# Crawford Apartments

## Tract A, Fountain Valley Ranch Fil. No. 6B

# Grading & Erosion

PCD FILE NO. SF235 & PPR2257

1 PLAN - SITE PLAN
A1.00 SCALE: 1"=20'

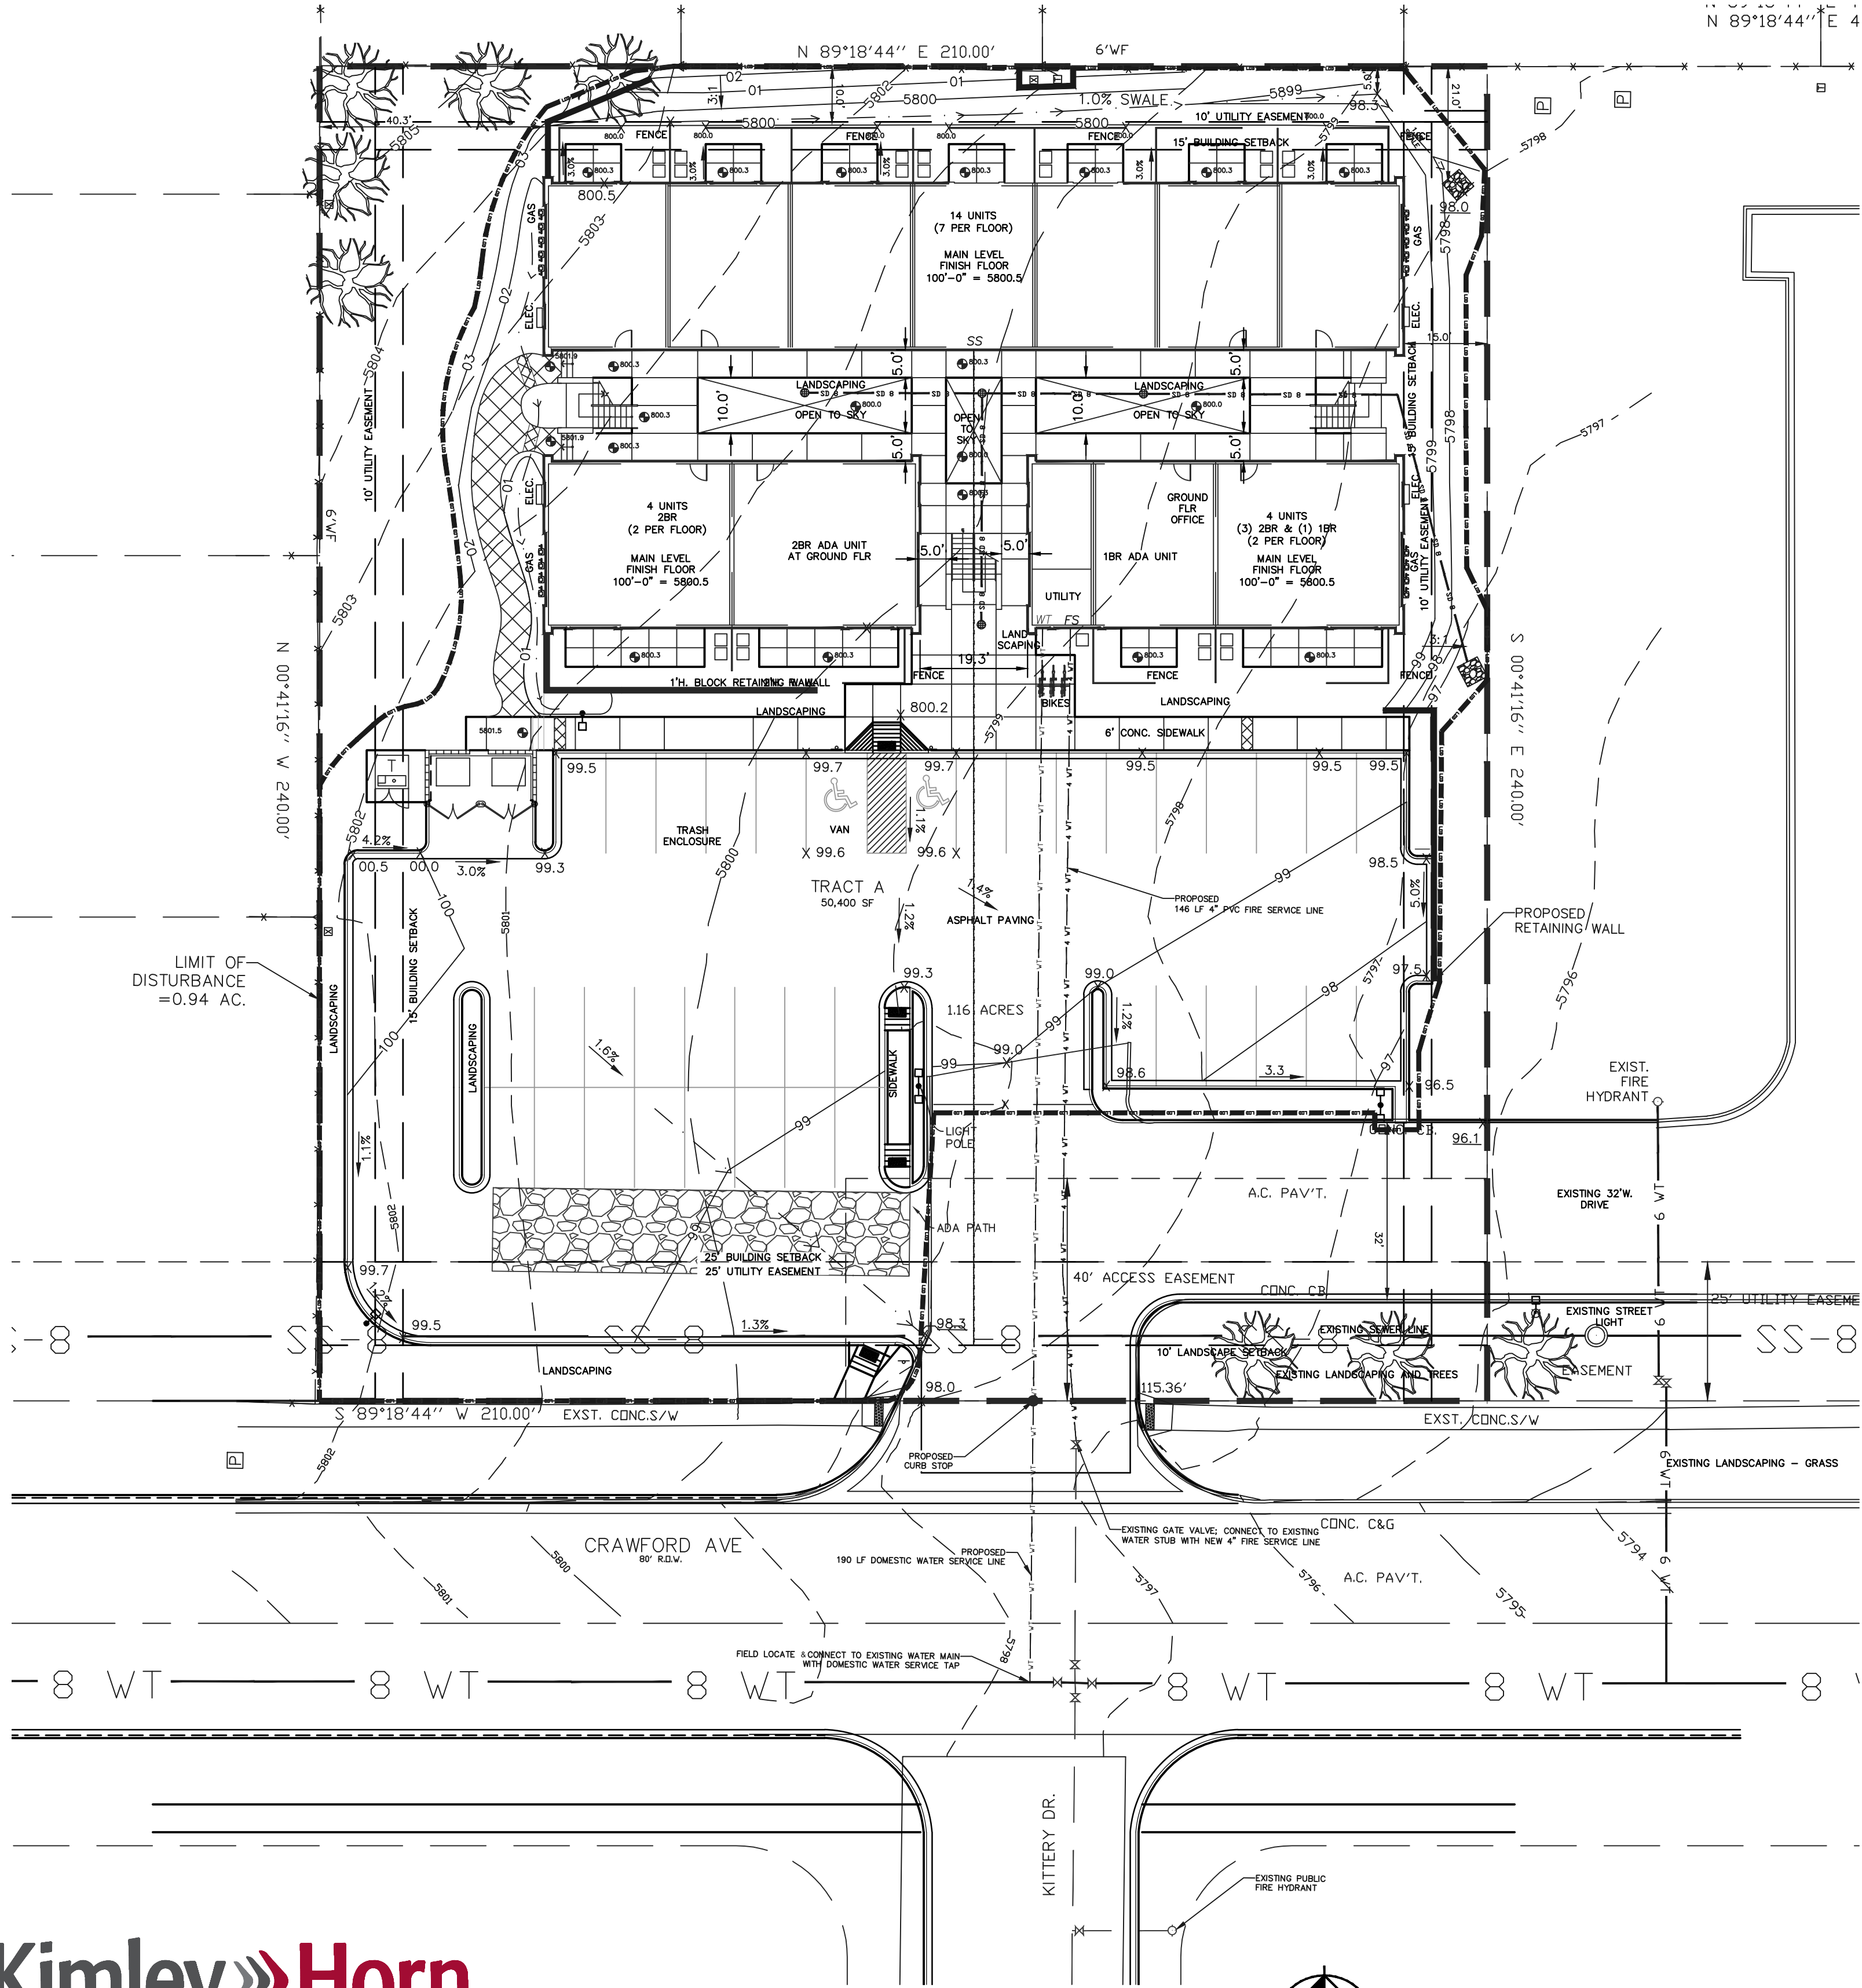
Comment Generated due to changes from the previous submittal - Limits of Disturbance and grading here do not match what is shown on the Site Development Plan. GEC Plan LOD appears to be accurate. update SDP accordingly.
